**From:** Steven Parisotto <Steven.Parisotto@griffith.nsw.gov.au>  
**Sent:** Thursday, 14 February 2019 7:31 AM  
**To:** Olivia Hirst  
**Subject:** Re: Notice of Section 4.55(1A) Modification - De Bortoli Winery

Our comments are as follows:

Figure 9 Additional Infrastructure Concept Plan

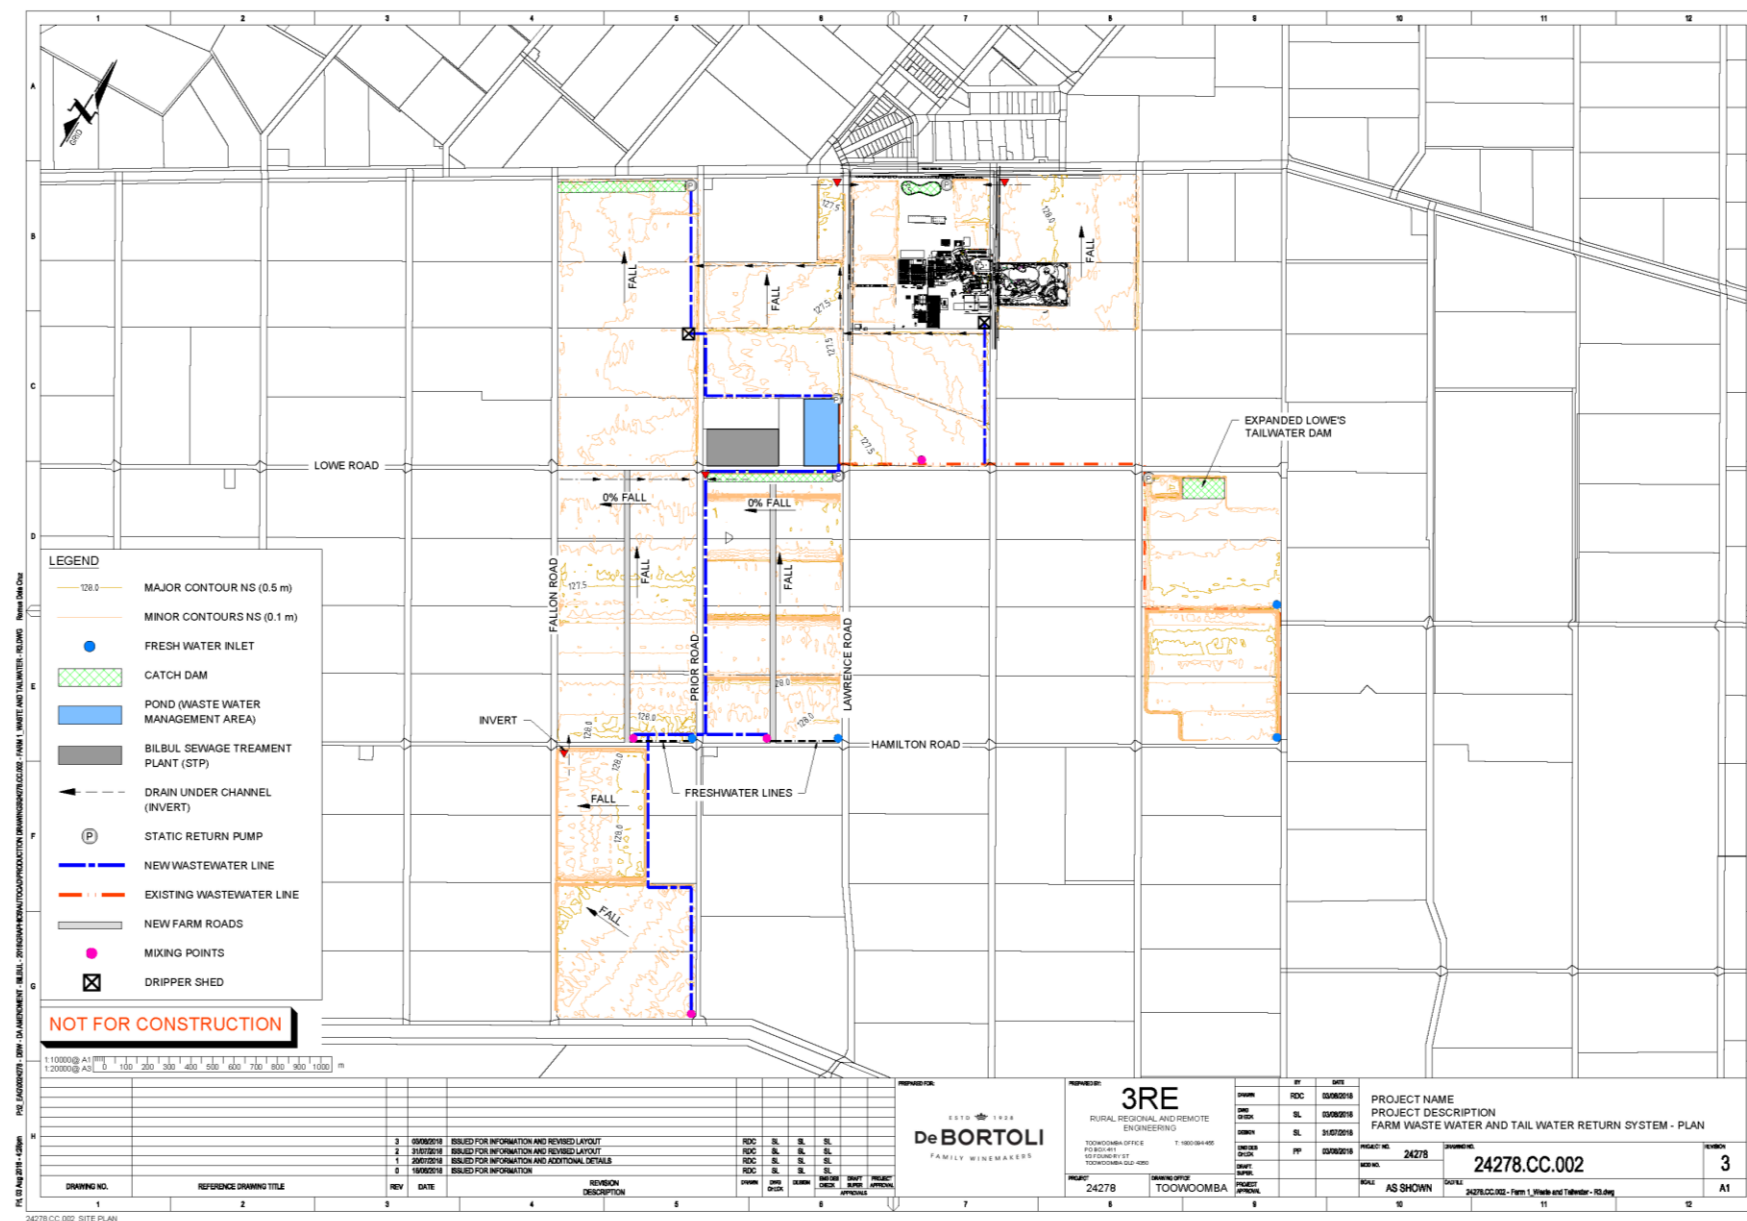
- Details including plans showing lot boundaries are to be provided as to how waste water will be directed to these allotments. Waste water pipelines are to be located within the property boundaries. Where these pipelines cross through or under Council road reserves and or Crown or MI reserves, land owner's consent is required. Where the pipelines, pumps and other associated infrastructure rely on Council owned or managed land, including within the road reserve the proponent will be required to enter into a lease agreement.

**Attachment F. Environmental Monitoring Report Review –  
Figure 8 (Amended)**

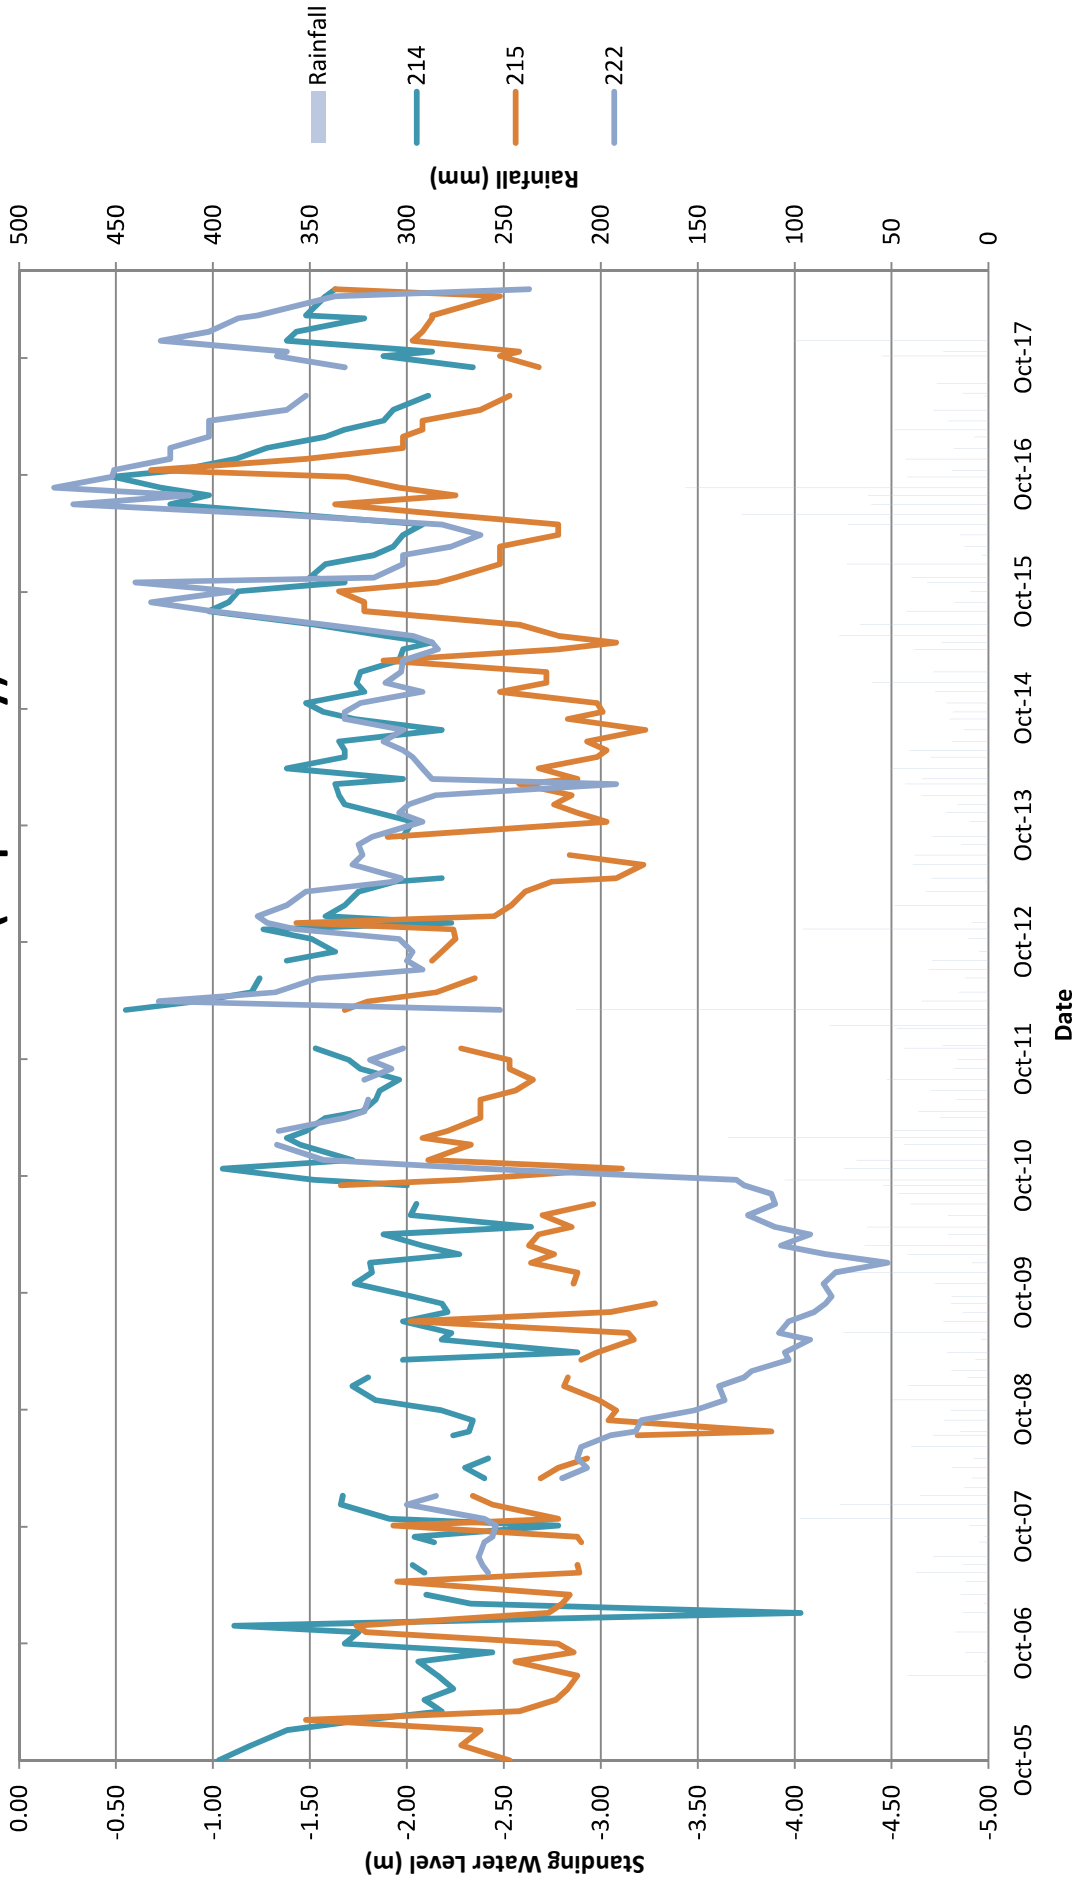
- Ensure piezometers are not located close to supply and drainage channels as these features can alter water table depth and ground water quality.
- Instead of retaining stubble, consider harvesting of stubble during and after each rotation to aid the exportation of nutrients off the site.

**Figure 2: Wastewater Utilisation Area Rotation Plan**

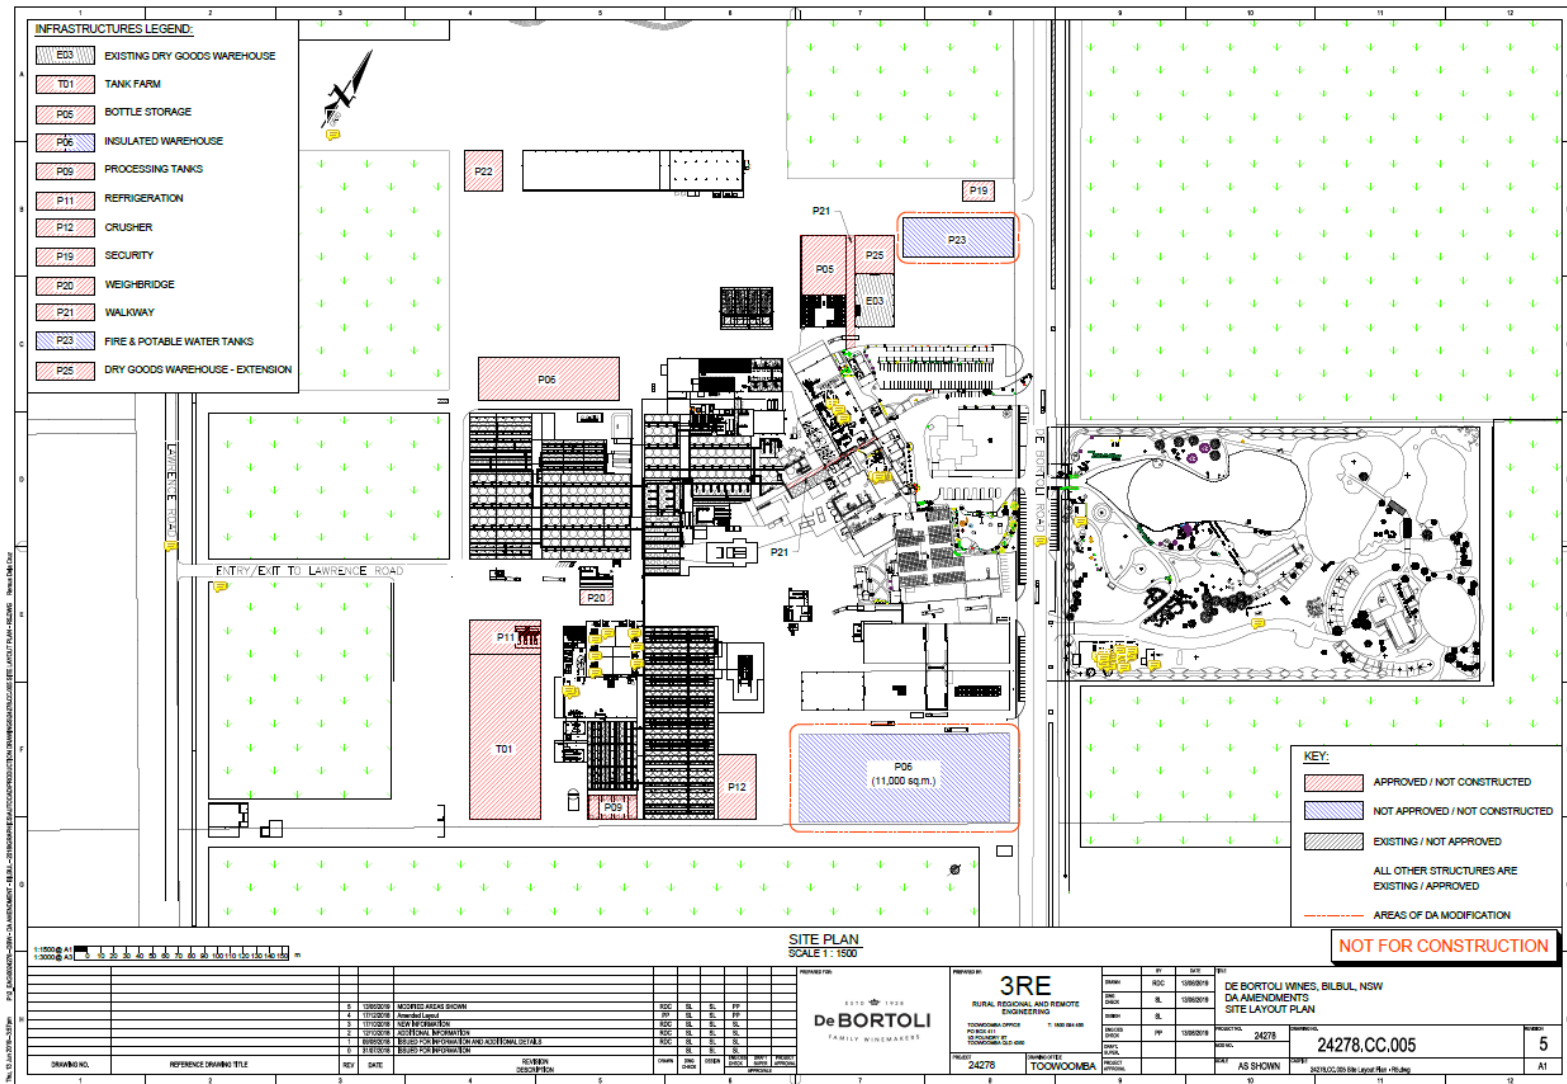
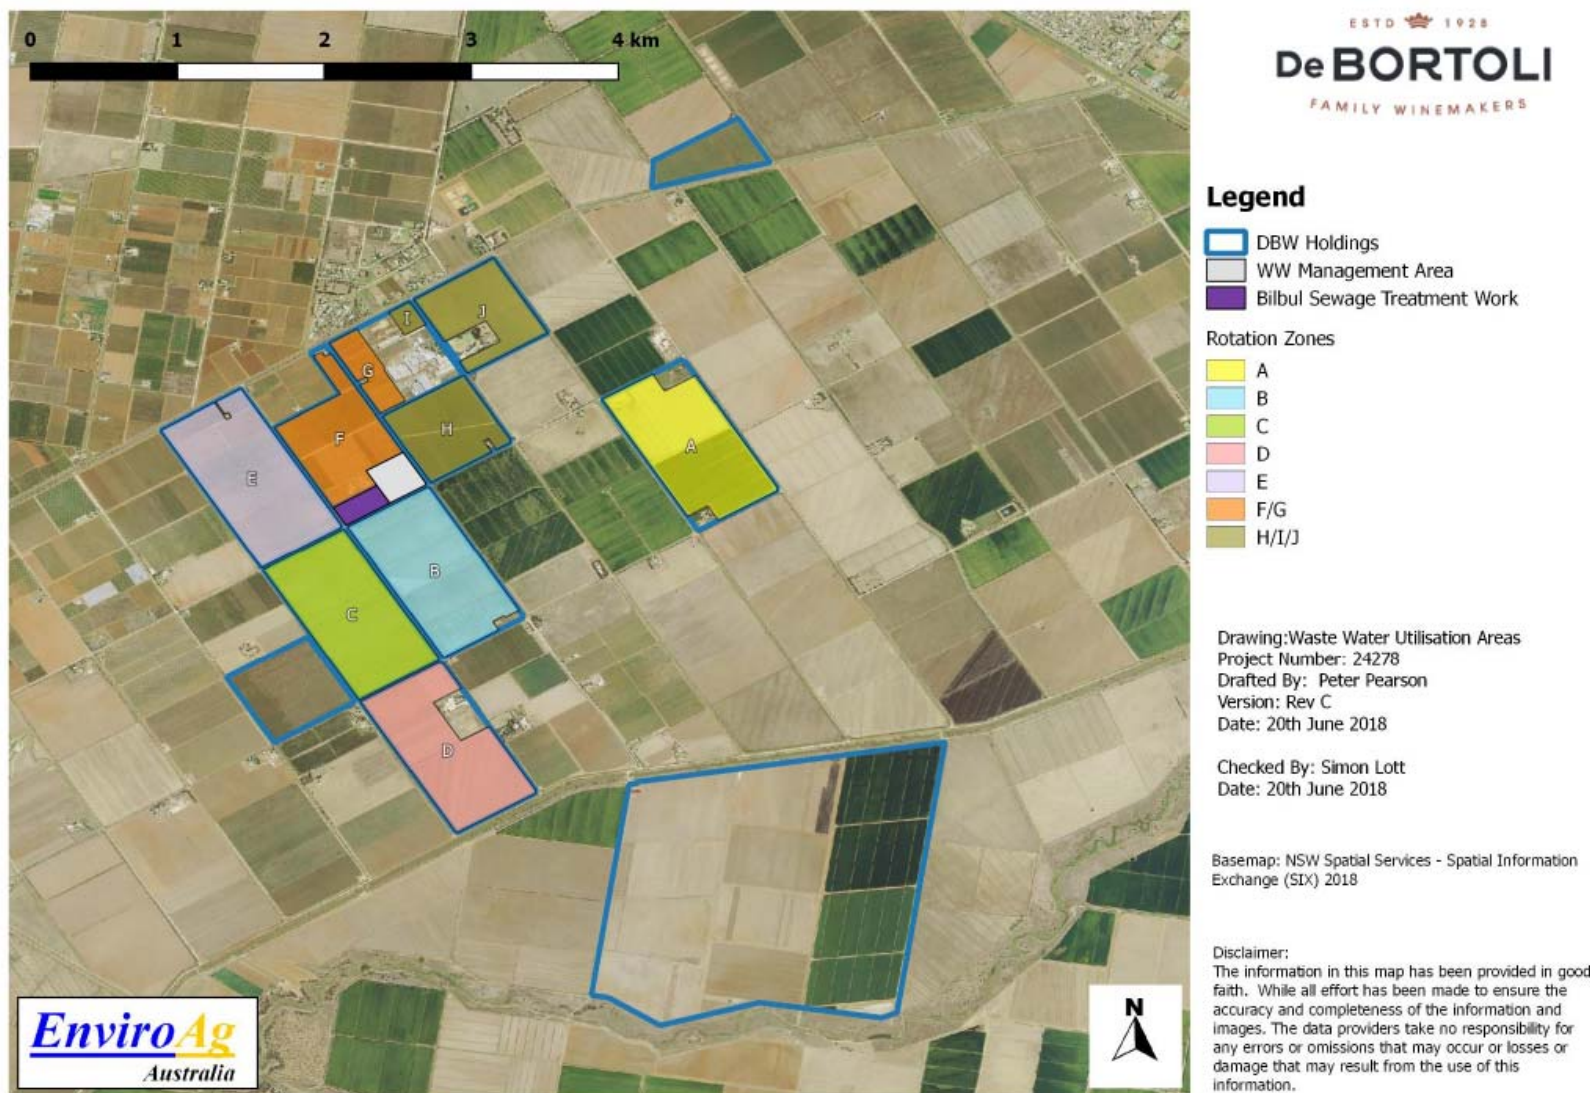
- Consideration of any odour issues where irrigation of waste water is irrigated close to residential village zones. In particular rotation zones F, G, I & J
